Y/55/22/DOC – CONDITIONS 8, 9 AND 10: DRAINAGE RESPONSE

Following the latest comments received in the email dated 26th April 2022 from Arun District Council's Drainage Engineer, this letter seeks to address the final outstanding comments pertaining to planning conditions 8, 9 and 10 under planning permission Y/55/22/DOC for the Crematorium, Bognor. This letter is to be read in conjunction with the previous email exchanges on the subject between ADC and CampbellReith.

Arun Crematorium

Project No.	Originator	Volume	Lvl/Loc	Type	Role	Number	Rev
13591	CRH	XX	XX	DR	C	5310	P1

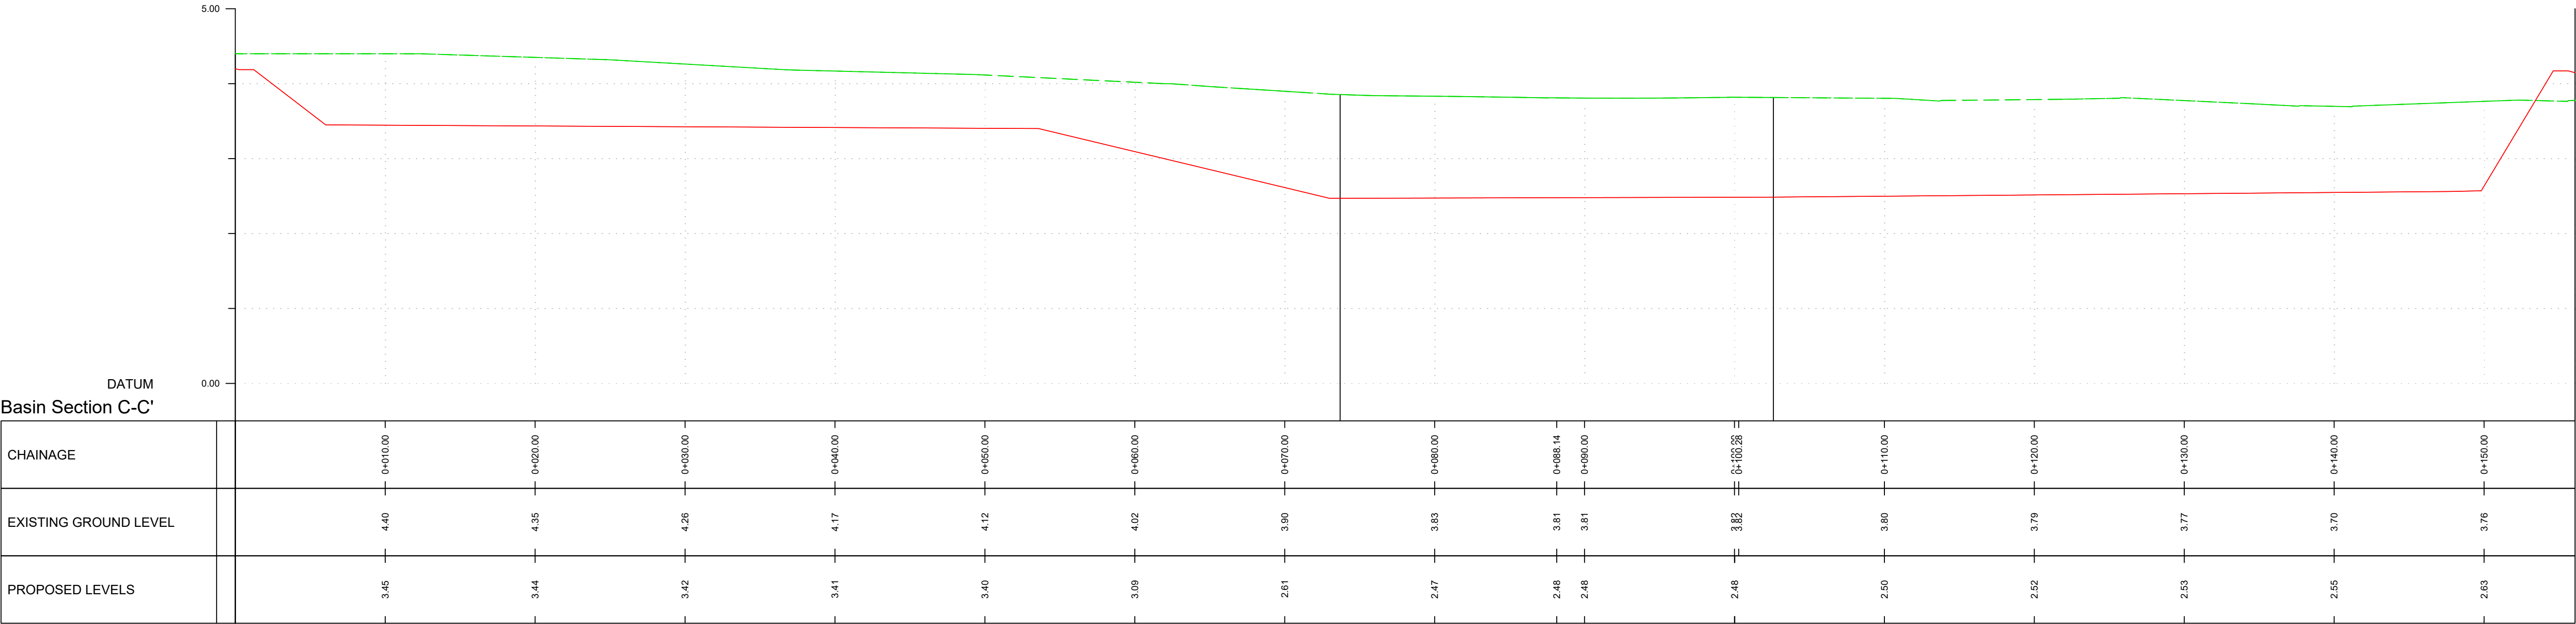
9. Please supply site specific construction details of the attenuation basin, showing invert level, top of bank level, width at bed and width at bank. Please see enclosed basin detail drawing 13591-CRH-XX-XX-DR-C-5310 Revision P1 . To be reviewed once principals are agreed.

9. Please see latest basin detail drawings (*13591-CRH-XX-XX-DR-C-5310 Revision P2* and *13591-CRH-XX-XX-DR-C-5311 Revision P1*).

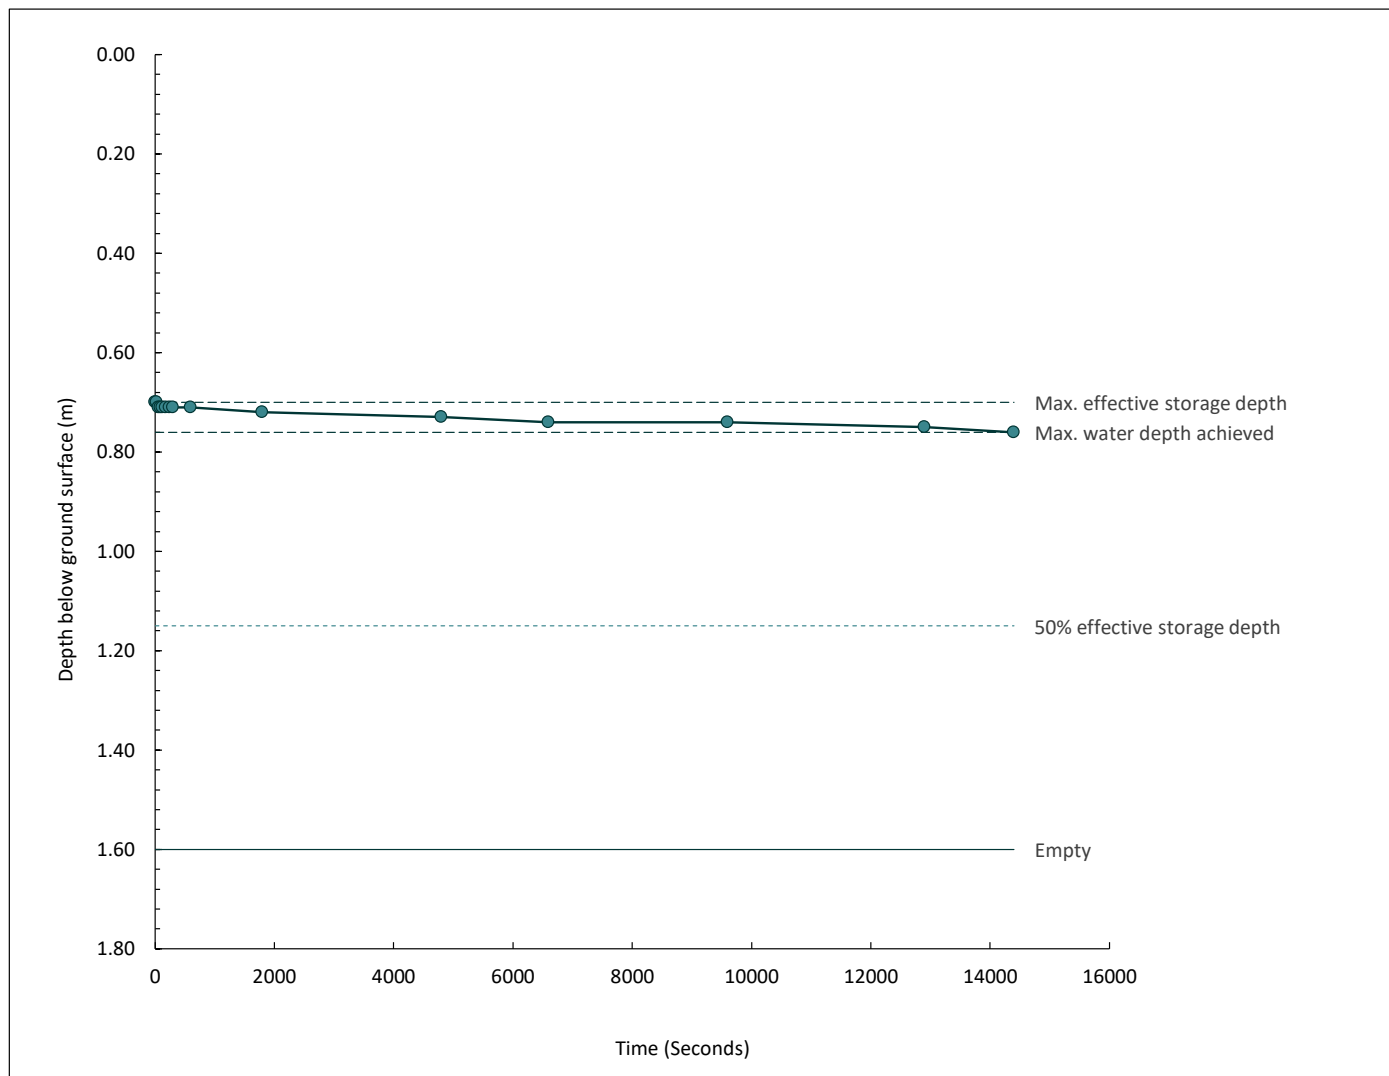
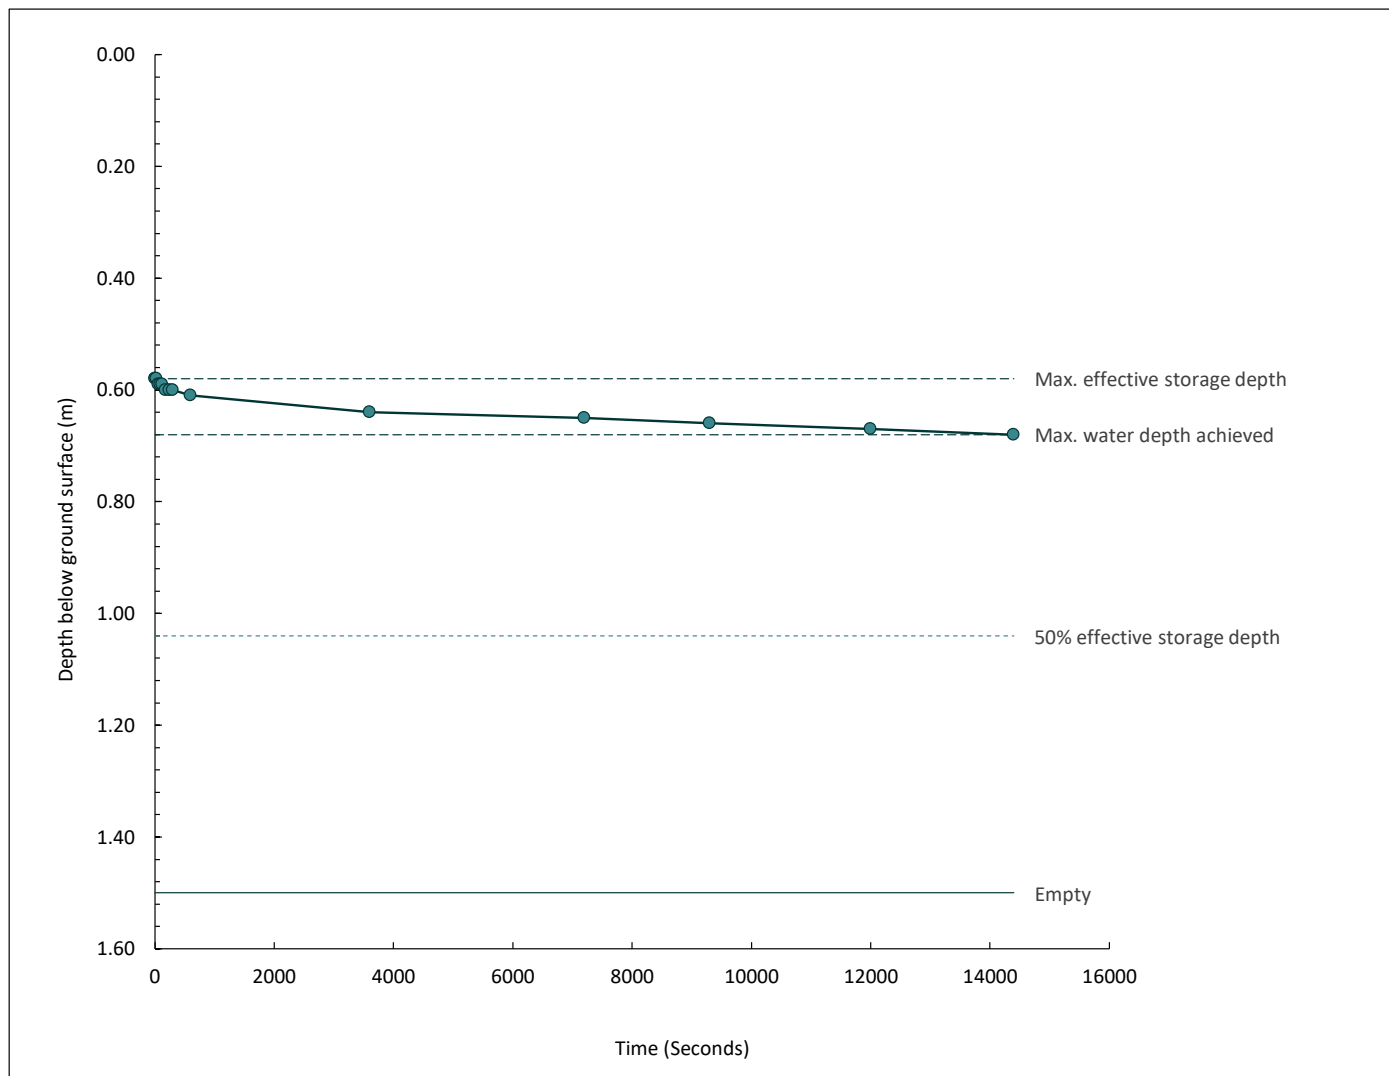
As per WSCC policy for the management of surface water policy 1- design must follow the hierarchy for sustainable drainage. Locations of groundwater monitoring and infiltration testing have not been provided. It is noted that groundwater was found to peak at circa 1m depth. Shallow infiltration testing was completed and gave rates which do not preclude the use of infiltration. Please supply evidence why the sole use of infiltration is not acceptable here. E.g. a design with infiltrating permeable paving, swales and shallow infiltration basin. A full review of responses to our other comments has not been completed as this fundamental issue must be addressed first before reviewing details. Please find attached layout plan showing location of the boreholes/ percolation test together with details of results -

It should be noted that percolation testing (despite having been requested by ADC) is not appropriate for use in the design of infiltration drainage systems. Percolation test should only be used for determination of drainage fields for foul drainage (please refer to Building Regulations Part H for guidance on this). CIRIA SuDS Manual C753, Section 25.3 states that infiltration testing should be undertaken following the BRE method and BRE 365 tests have been undertaken for this site

and yielded no infiltration. Please see attached for further details relating to those tests.

Project No.	Originator	Volume	Lvl/Loc	Type	Role	Number	Rev
13591	CRH	XX	XX	DR	C	5250	P1

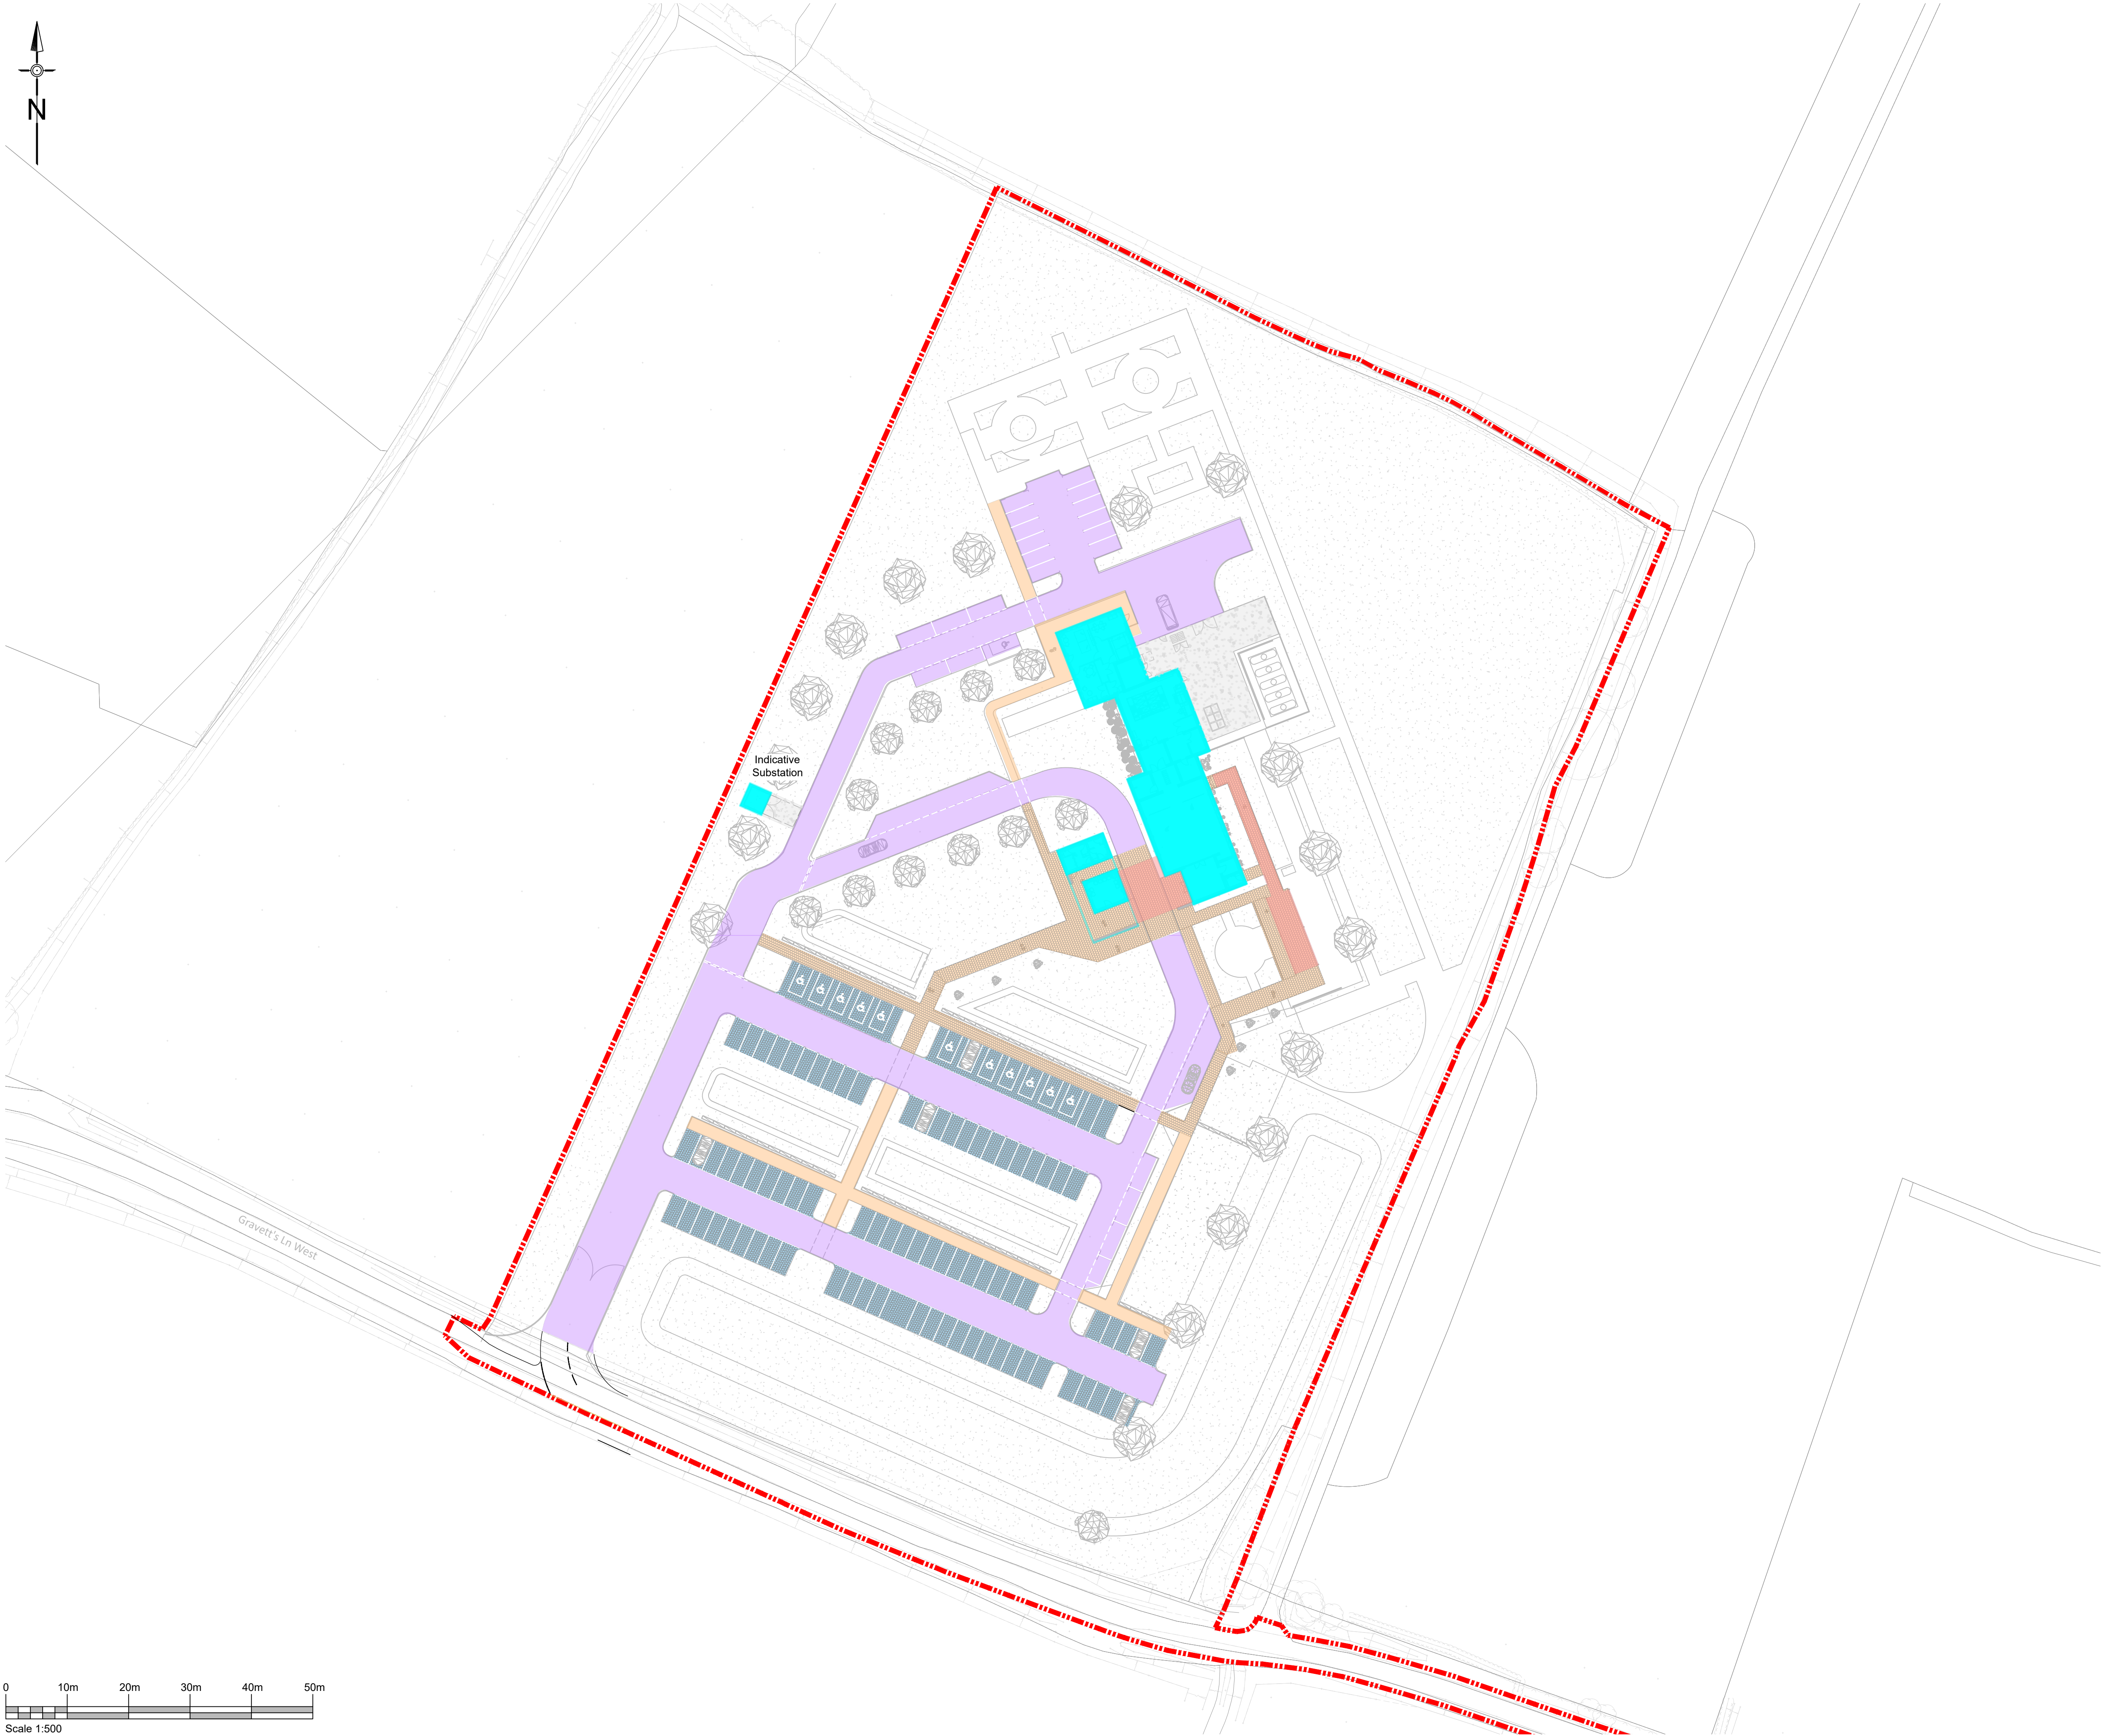
3. Please supply an impermeable area catchment plan. Please see enclosed impermeable area plan 13591-CRH-XX-XX-DR-C-5250 Revision P1. Okay. We have also included the additional detailed sub-catchment plan 13591-CRH-XX-XX-DR-C-5260-P1 to accompany the drainage calculations and provide absolute clarity as to which areas contribute to the model. *To be further reviewed once points 1 and 2 are addressed.*

3. Please see enclosed sub-catchment plan (*13591-CRH-XX-XX-DR-C-5260 Revision P2*).
4. Please refer to latest drainage layout plans (*13591-CRH-XX-XX-DR-C-5050 Revision P8* and *13591-CRH-XX-XX-DR-C-5051 Revision P7*).
